OBJECTION CM/64/19/PL Langford Horsemere Green Lane

Planning Objection: CM/64/19/PL Langford, Horsemere Green Lane BN17 5QZ

Drawing Title:
STREET SCENES/SECTIONS

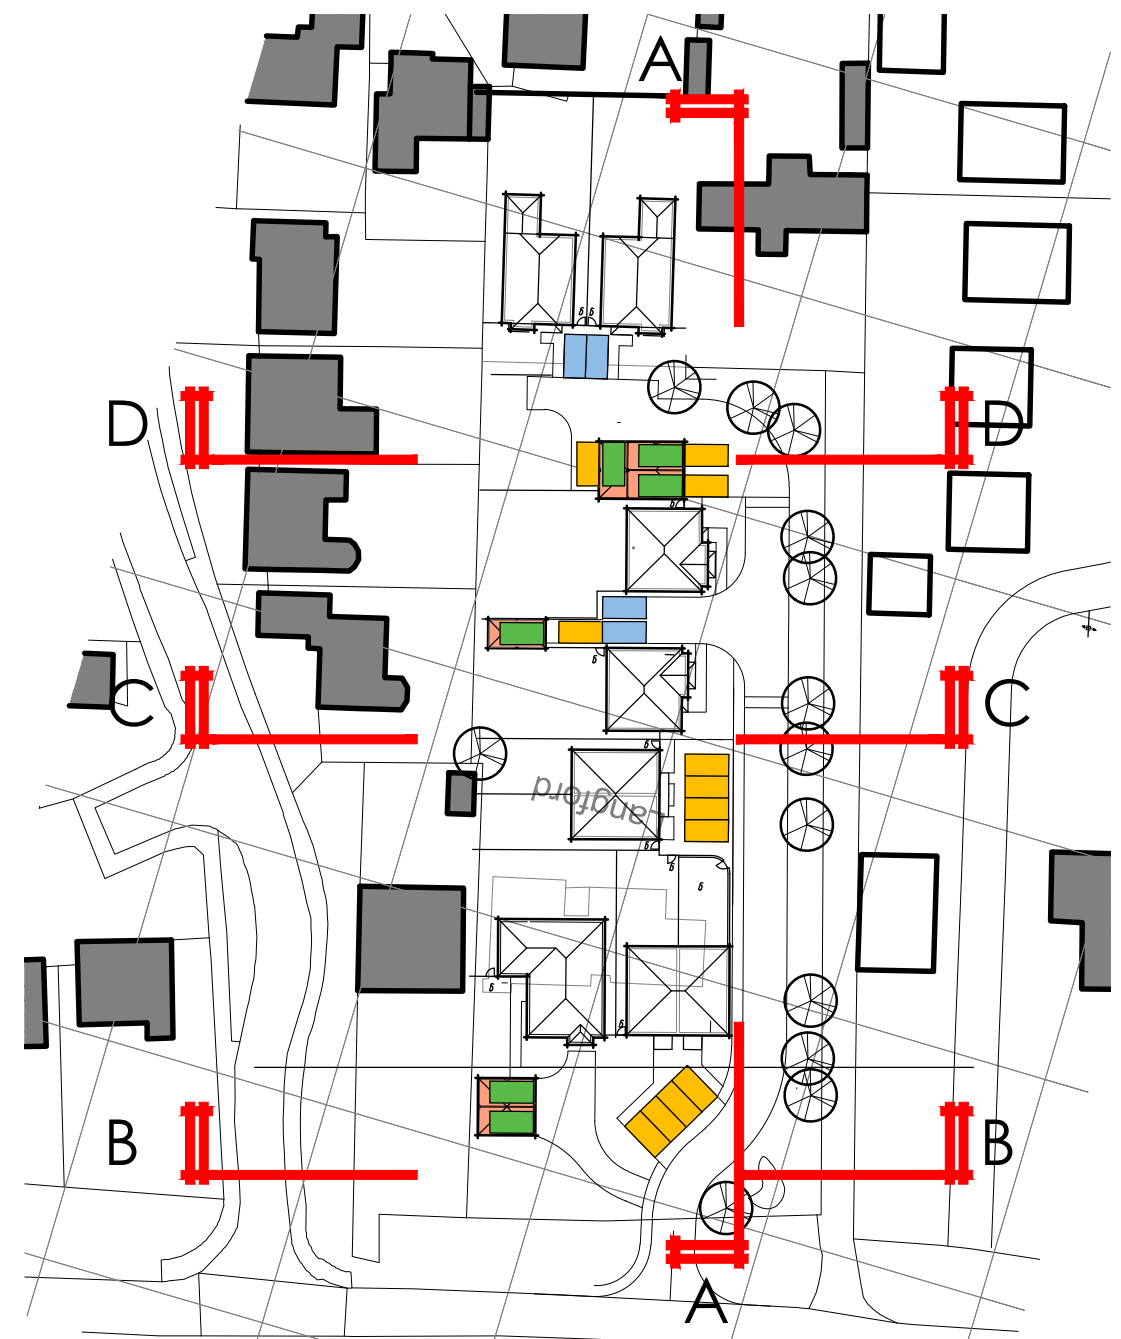
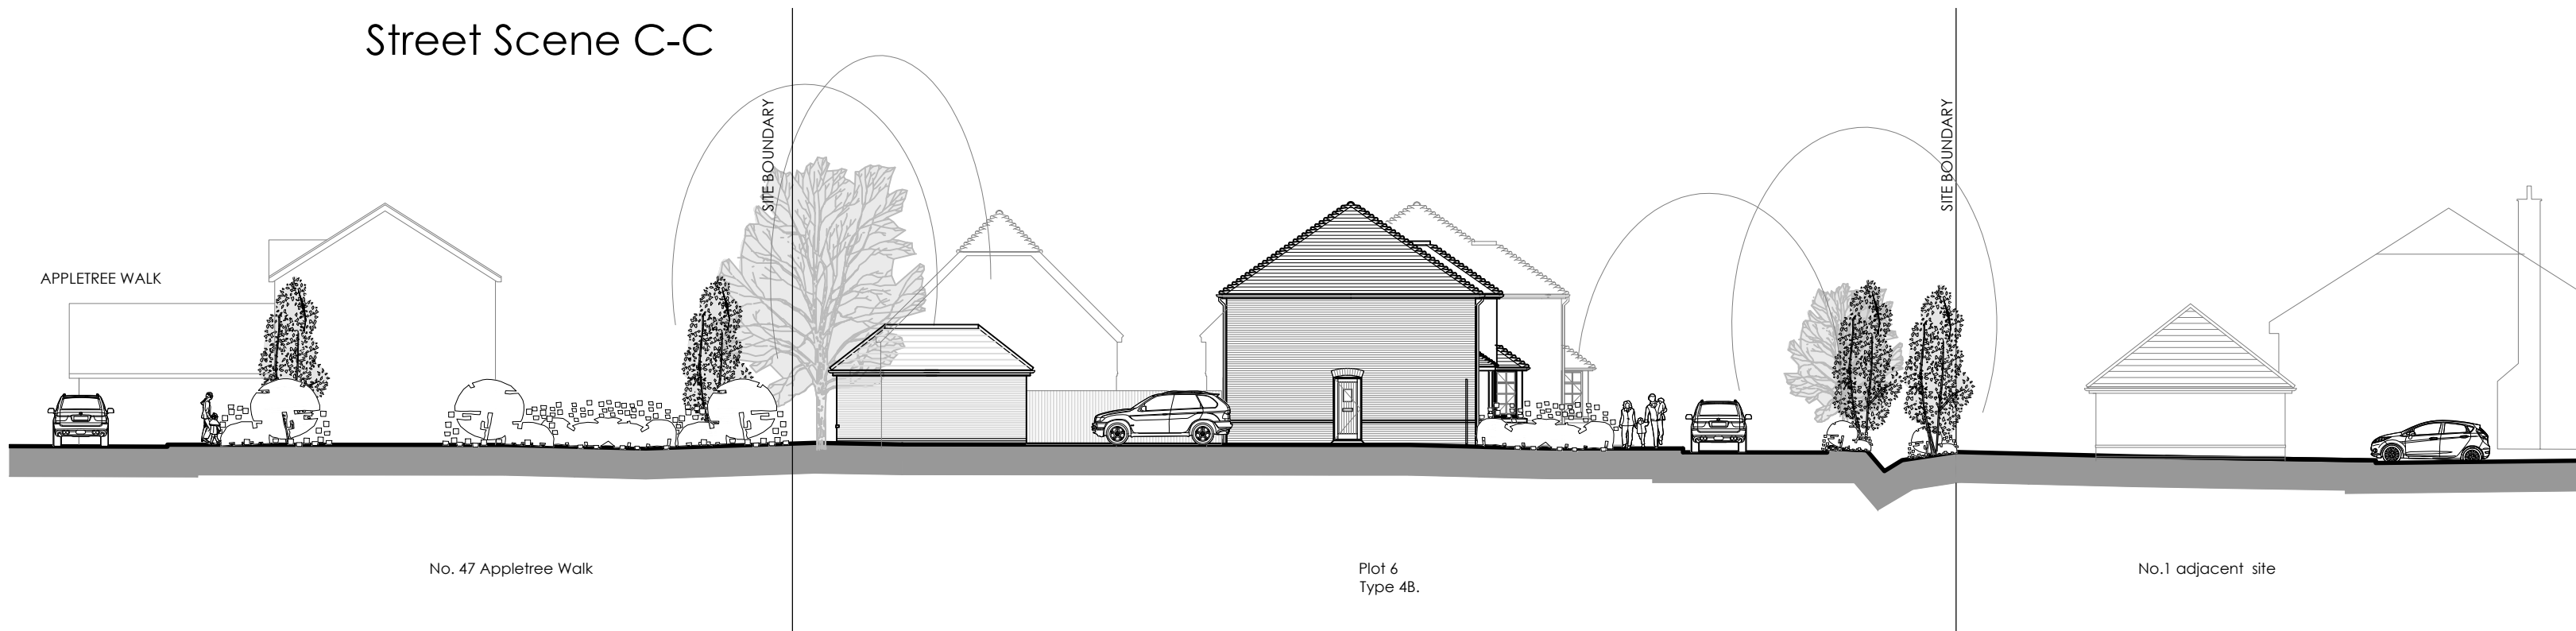
3. The value of my property has been badly affected.
4. PLOT 8 runs the length of my boundary. An application for a 4-bed house type E has been superseded by House type F described as a **3-bed BUNGALOW**. Having looked at the plans this is a **HOUSE** with 2 bedrooms and 2 bathrooms on the first floor, and one bedroom on ground floor. The whole length of the proposed house runs the whole length of my boundary, with permanent structure within feet of my fence. This is very intrusive, and will obliterate light for the majority of the day, completely unacceptable. I speak on behalf of myself and my affected neighbours.

6. If the applicant were to reduce the roof height to single storey, ie, that of a bungalow, as proposed, and lower the ground level, this would fall in line with their proposal of '**2 x 3-bed bungalows**' made to Arun District Council.
